RE: Staff Review Comments for Amendments to Approved Plans for 130 Eastern Promenade

Project Name: 130 Eastern Promenade Plan Amendments
Address: 130 Eastern Promenade
Applicant: Eileen Simko-Minte
Planner: Nell Donaldson

Project ID: 2013-236
CBL: 003 C001001

Job Number:
File:
Date: 8-12-2011 Scale: 1" = 10'-0"
Drawing Number:
L-4.0
© 2011 CARROLL ASSOCIATES

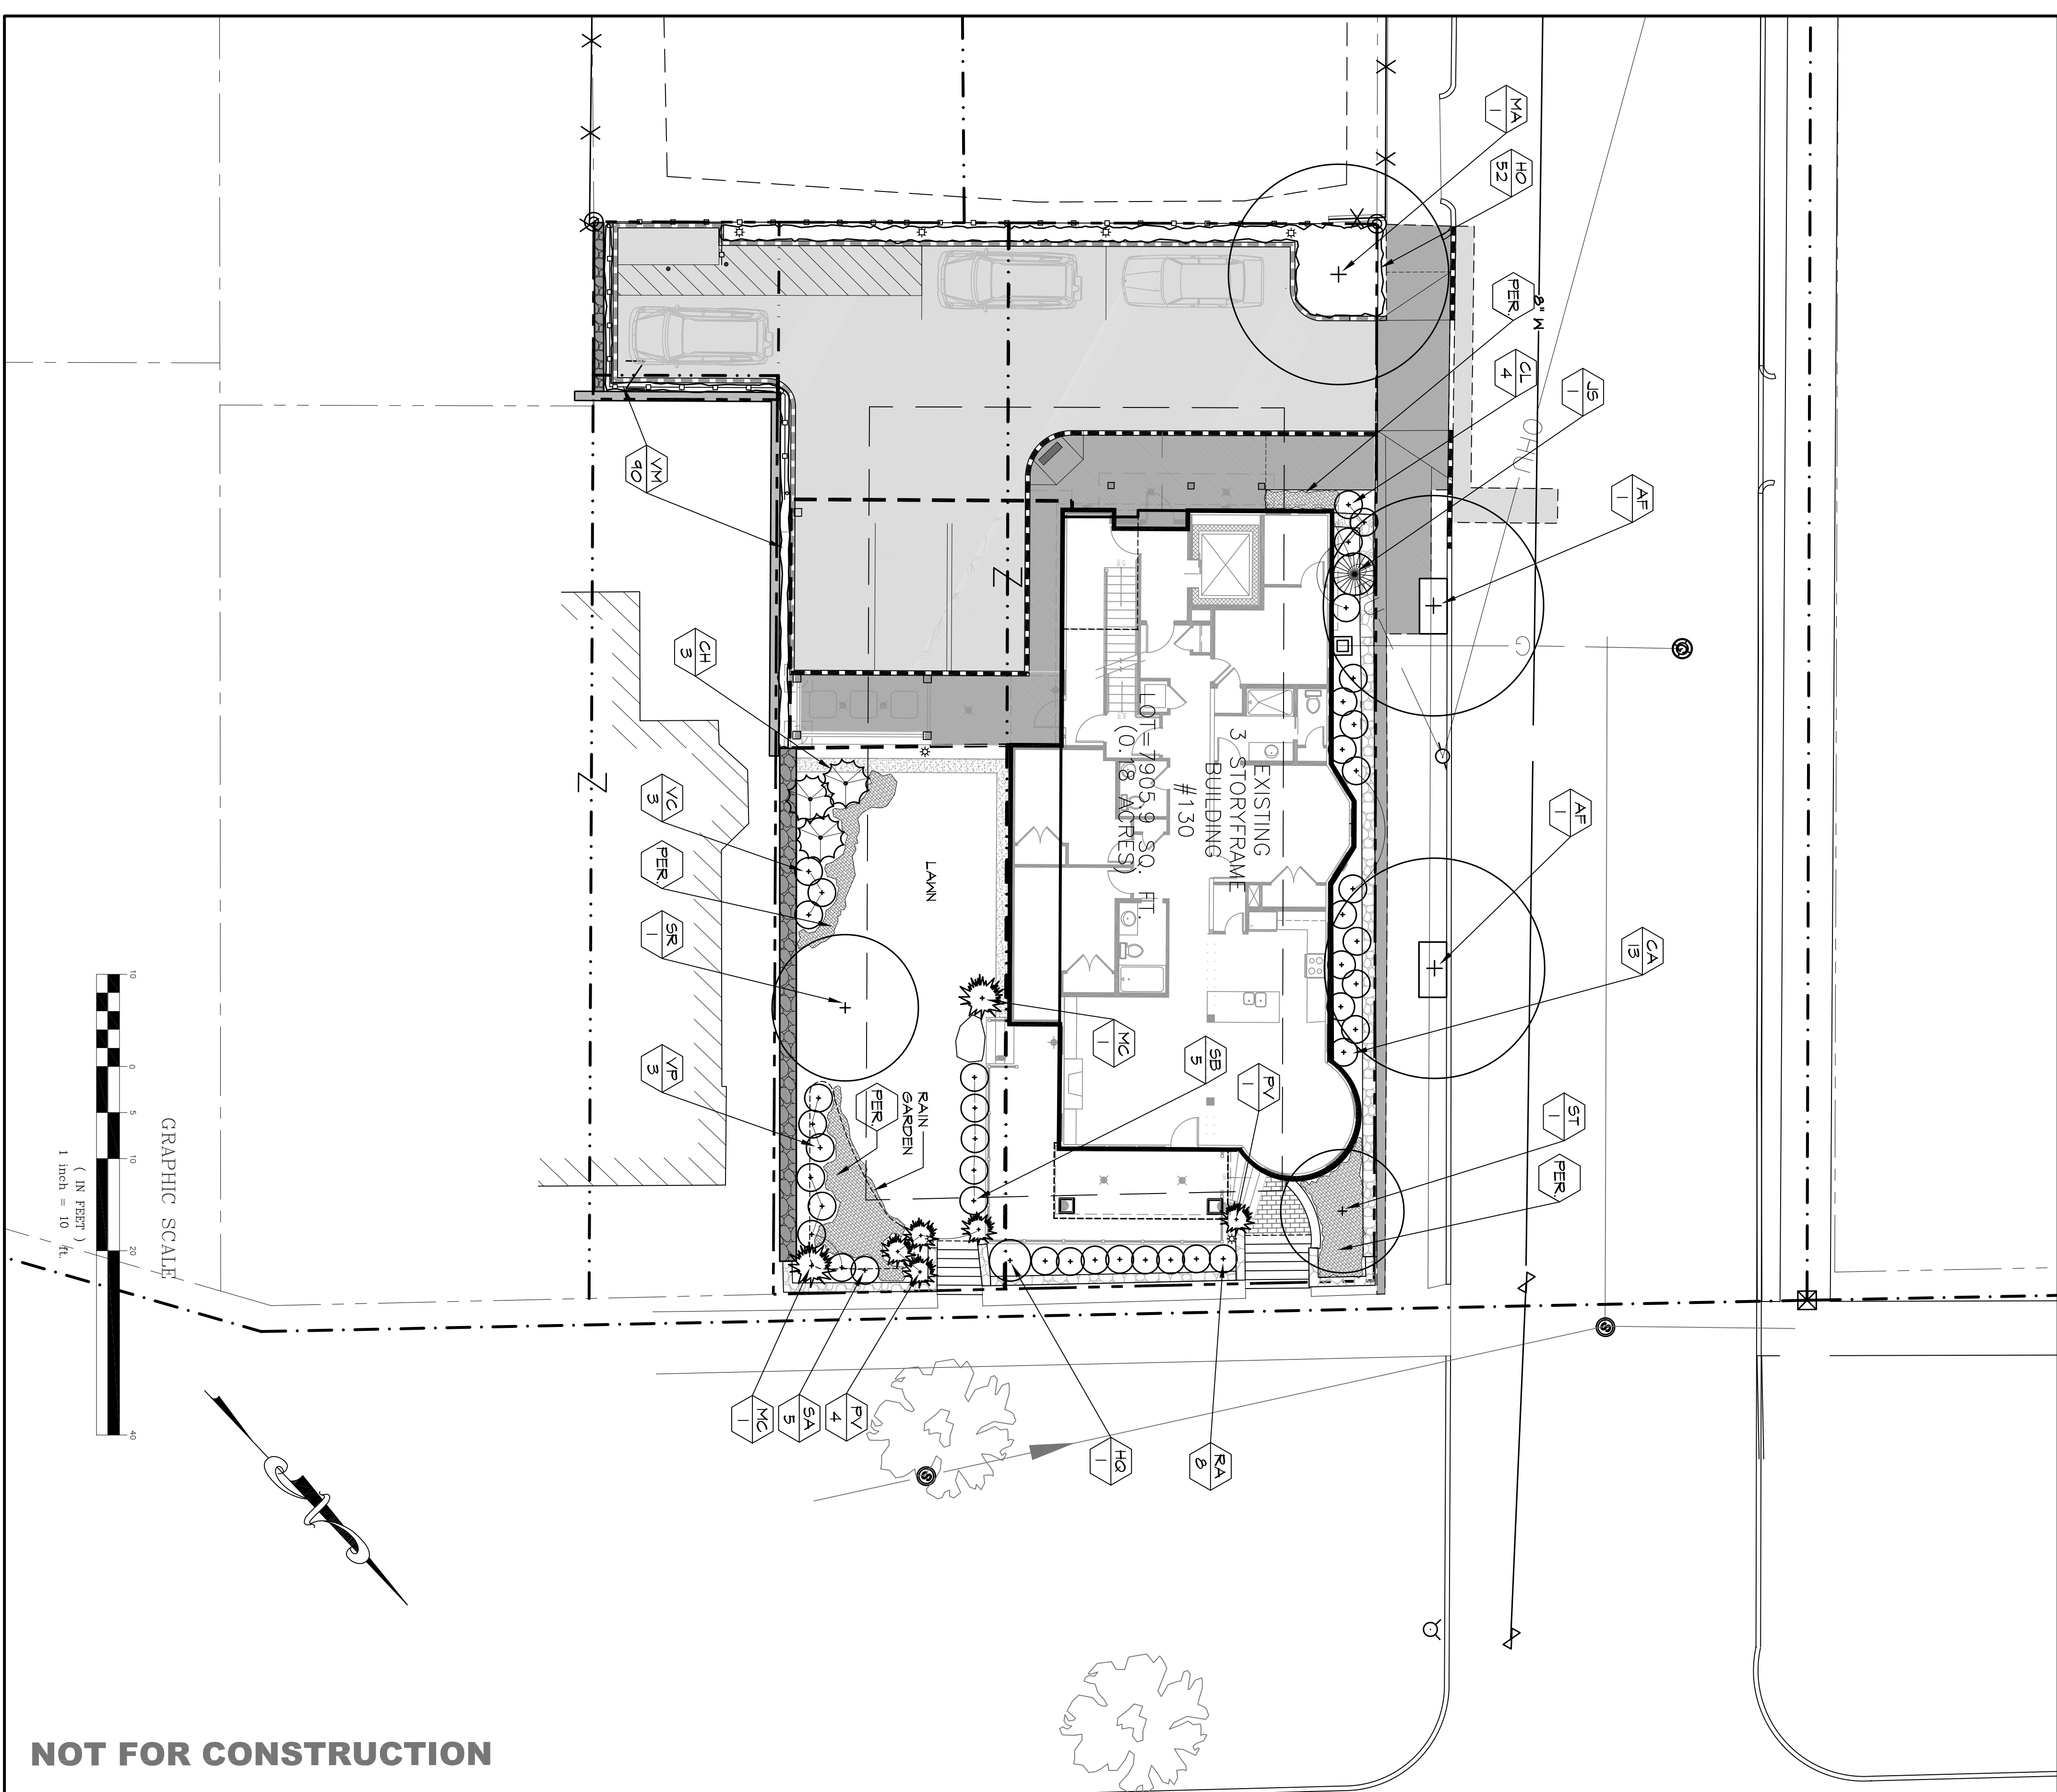
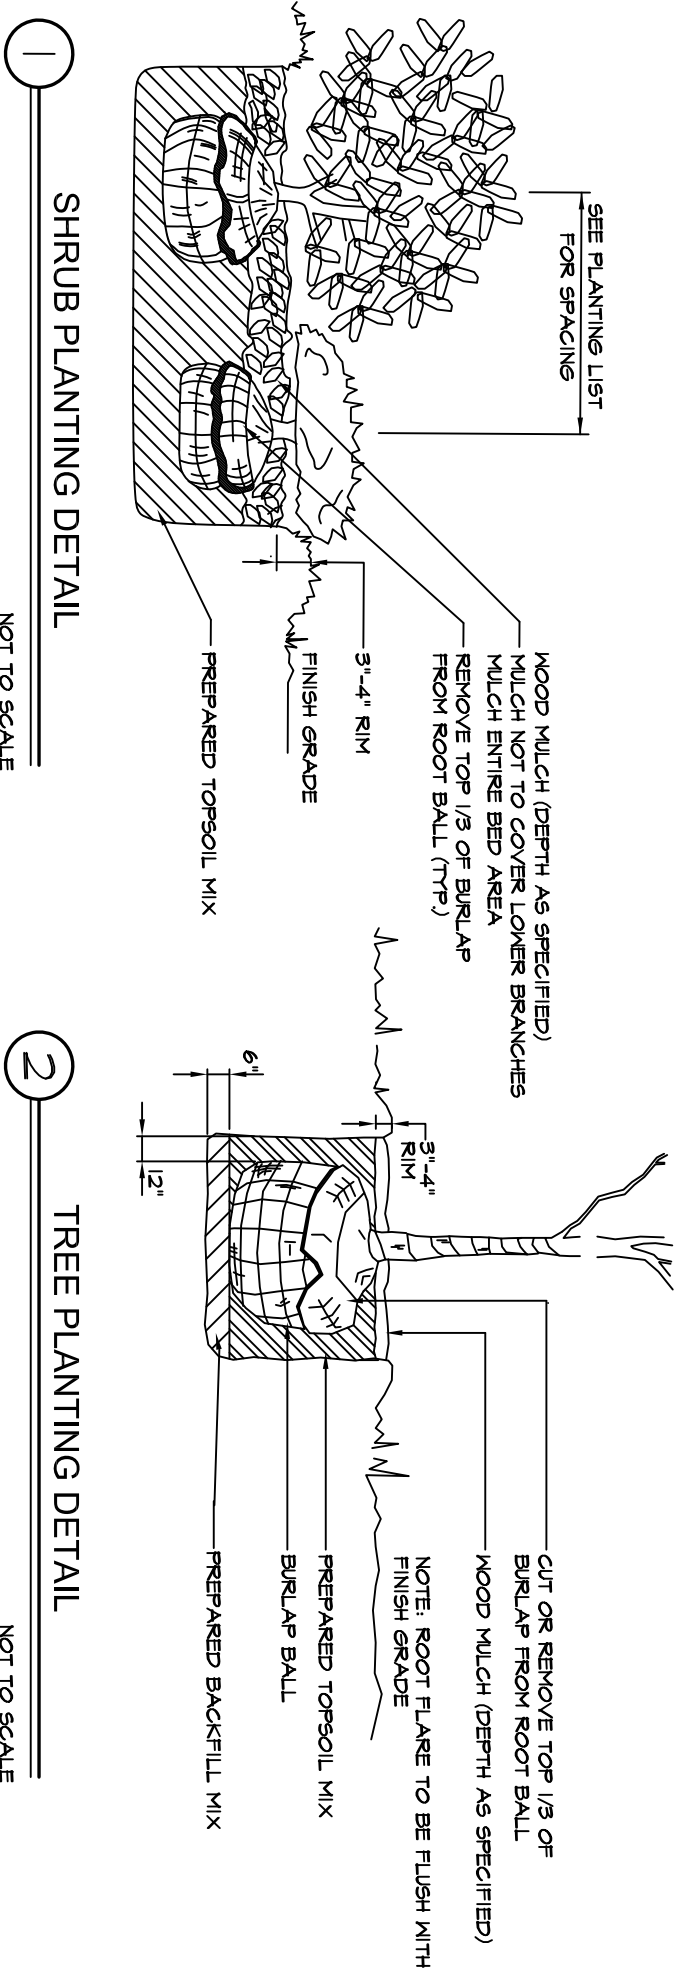
The project proposes two new street trees along Wilson Street. Due to overhead utility lines overhead on the second tree (away from E Prom) that tree should be a smaller tree such as Sargent Cherry, Japanese Tree Lilac vs the 'Armstrong' Red Maple as shown. The maple is good for the tree closest the prom with no overhead wires.

The project should review tree planter width recommended at 3.5' min and ideal at 4'. Sidewalk needs to comply with ADA standards on width. This may require a cut-out in the sidewalk and tree grate.

Review and increase plant sizes for the 1 gallon plant sizes to 3 gallon size on 'Grow-low sumac, the crab-apple recommendation would be "Adirondack". Options for the proposed Japanese Tree Lilac could also be dogwood or crab-apple.

Please extend the proposed tree planter cut out to 3.75' wide from inside face of curb to be consistent with cut outs up the street.

The back property line near the proposed parking should include a low wood fence to screen car parking along with a complement of landscape treatment. The landscape treatment or planting should include shrub planting to help as a screen. The ideal height would be 5 - 6', perhaps 'Korean' Lilac size... the available planter width along the property line should be widened to perhaps 3' if possible to accommodate this planting space. Narrowing the proposed paved walk space between the drive and building could be reduced perhaps to find space.

Could the trash dumpster be moved up toward the street equal to the car parking area, approximately 6 - 8' to provide landscape space in the corner?

4 CONC. MODULAR BLOCK RETAINING WALL DETAIL
NOT TO SCALE

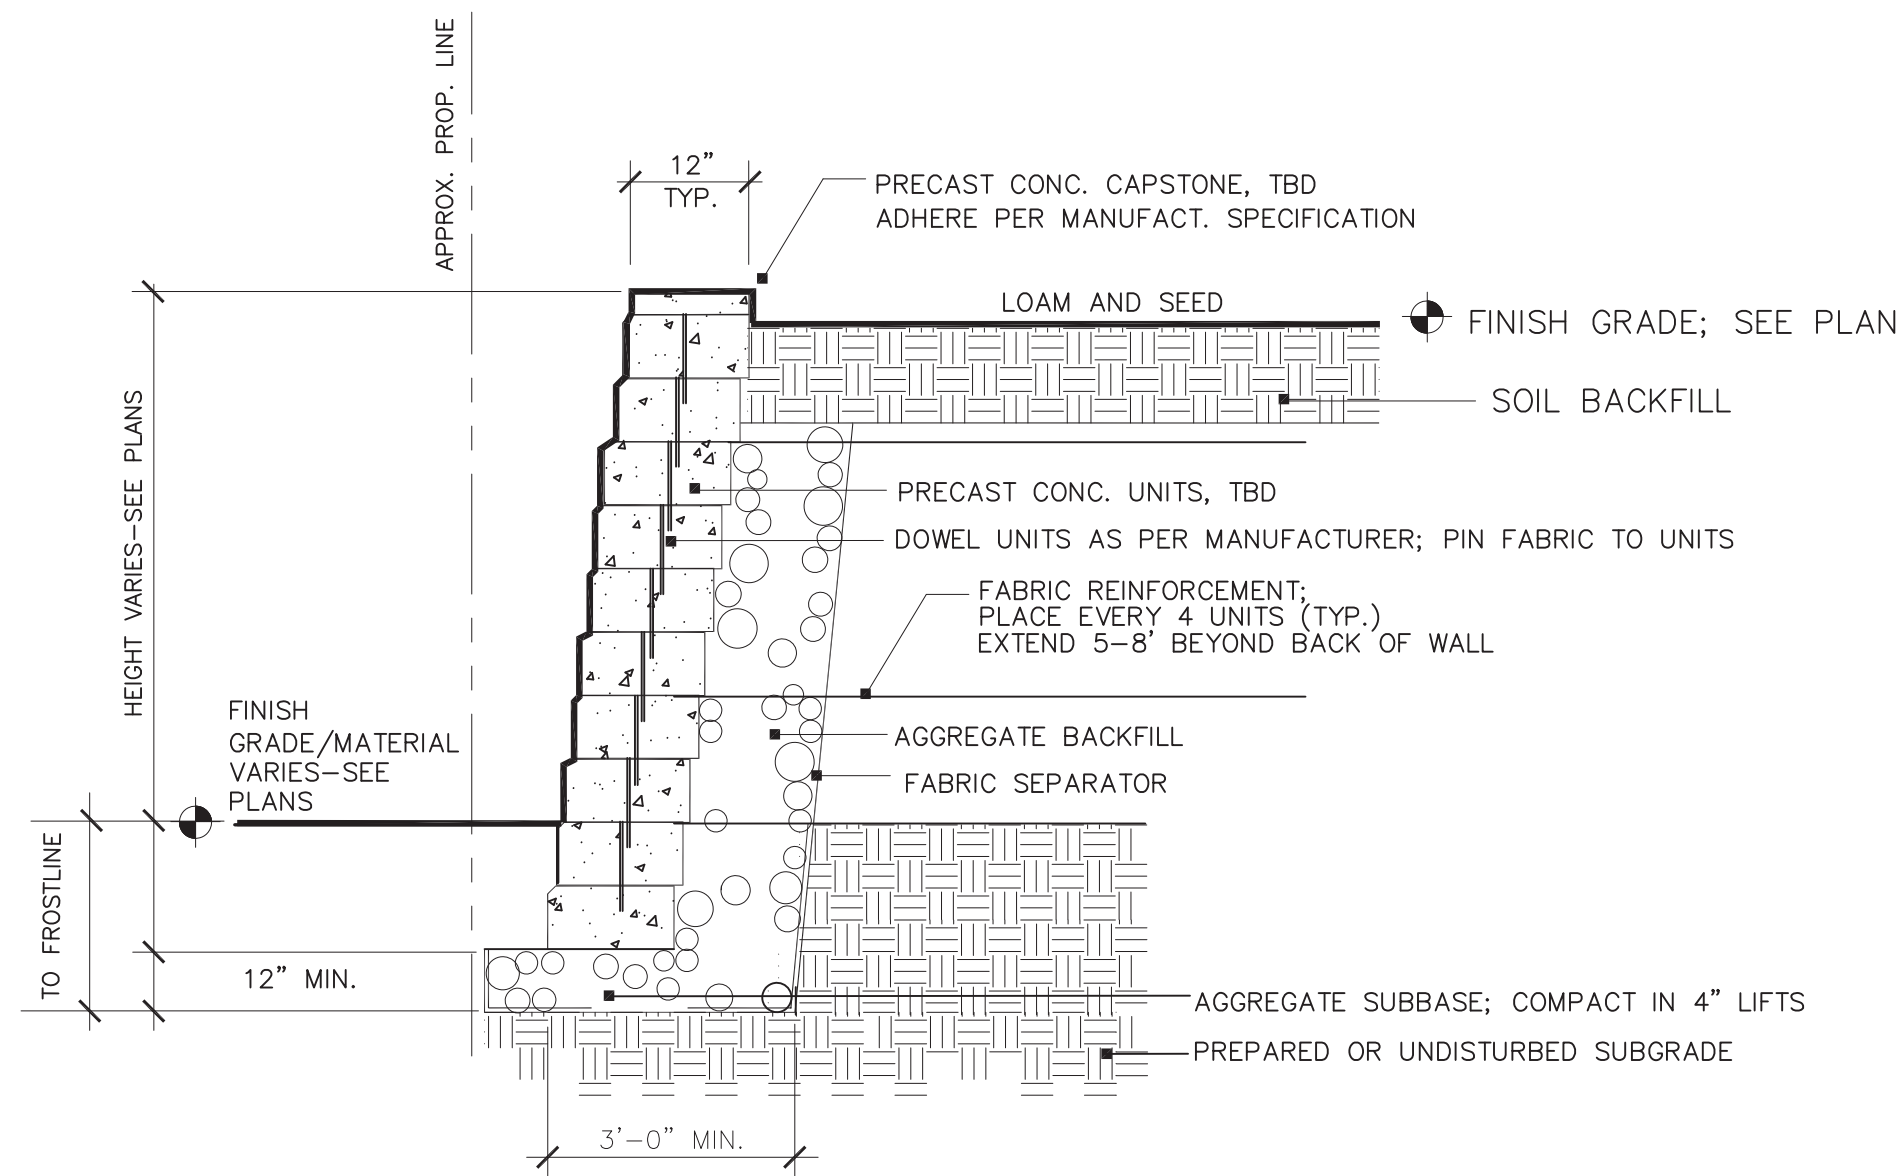
The rain garden details on sheet D-1.0 and the retaining wall detail on L-5.1 indicate that an underdrain will exist below the rain garden and at the base of the retaining wall; however, no underdrains are depicted on the site plans. If an underdrain is required for these systems, we encourage day-lighting the underdrain(s) in lieu of a direct connection to the combined sewer; clarification should be provided on the plans and/or details.

9 TRASH ENCLOSURE
NOT TO SCALE

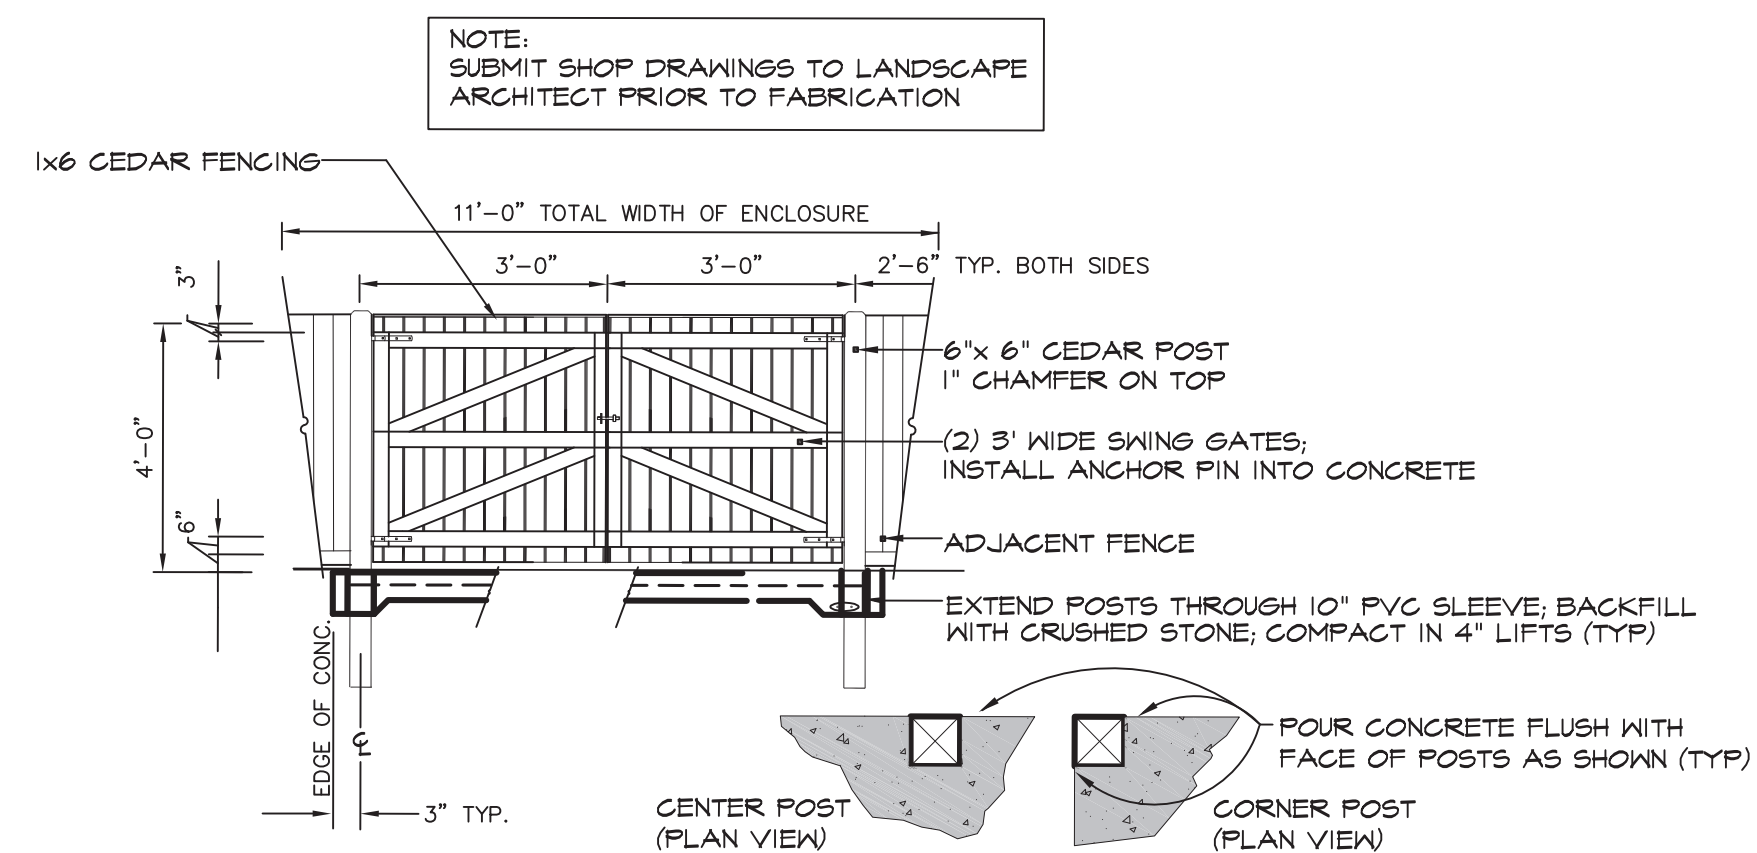
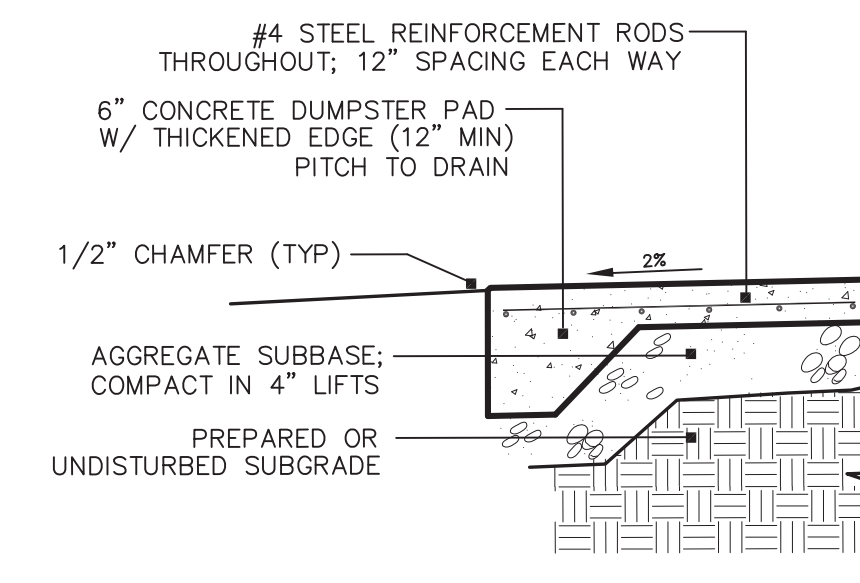
As previously noted regarding the trash area, which appears to have moved closer to the adjacent

property, additional details should be provided in revised plans. These details should indicate how the proposal for the trash and recycling area has changed, how the area is now proposed to be enclosed, if at all, and proposed dimensions (including distance to the property line). Additional landscaping in this area should also be considered, in order to enhance screening.
